**Response to Planning application from Hertfordshire County Council (T and CP GDP Order 2015)**

District ref: 6/2022/1812/FULL  
HCC ref: WH/13677/2022  
HCC received: 5 September 2022  
Area manager: Matthew Armstrong  
Case officer: Steven Knight

35 NORTHAW ROAD EAST CUFFLEY POTTERS BAR EN6 4LU

Installation of new crossover

SITE PLAN
SCALE 1:500

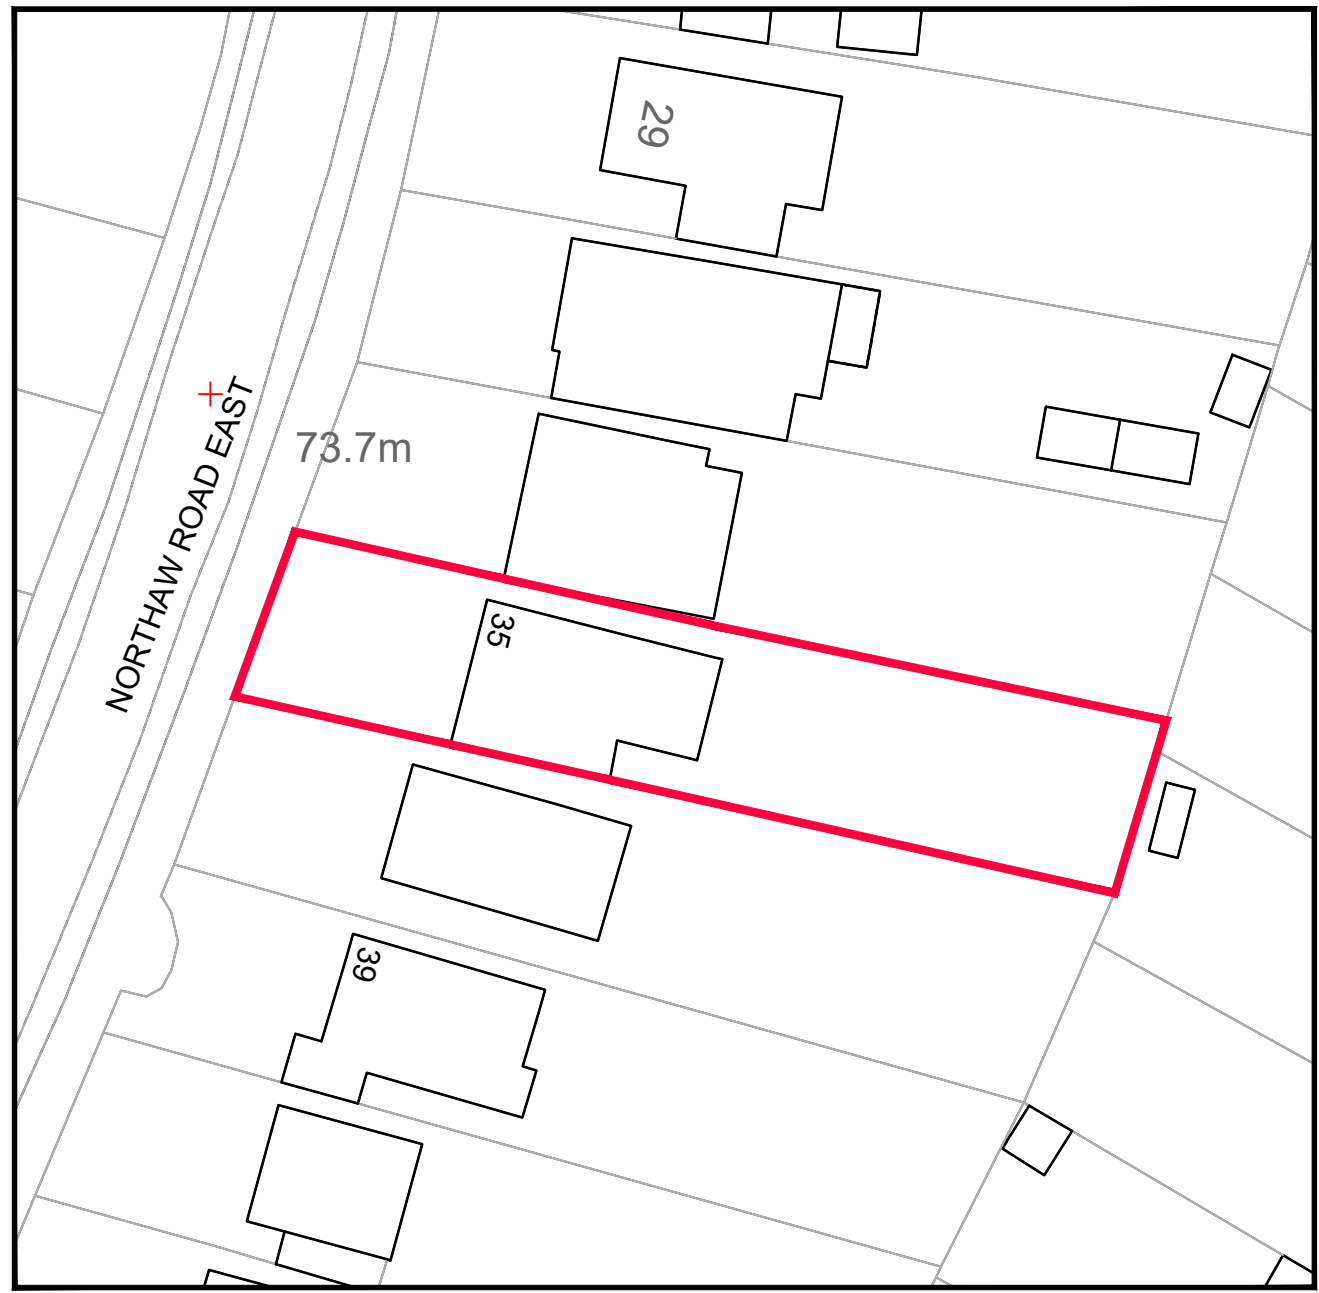
In relation to second vehicle crossings, HCC's dropped kerb terms and conditions states the property frontage must be at least 13.6m wide, but the Site Plan shows that the property frontage is only 11.5m wide. It also states that a gap of at least 4.5m of full height kerbs should be retained between

the two crossings and whilst the Site Plan appears to show a gap of 5m this incorrectly includes the dropper kerbs.

The terms and conditions also state that carriageway drives are approved because 'it is safer to drive off a property in forward gear' and this is particularly important on a classified road such as Northaw Road. However, in this instance the property frontage is comfortably large enough to accommodate multiple vehicles whilst still providing enough turning space so that a vehicle can turn around and leave the site in a forward gear using the existing crossing. The highway authority therefore concludes that the second crossing is not required for the purpose of highway safety.
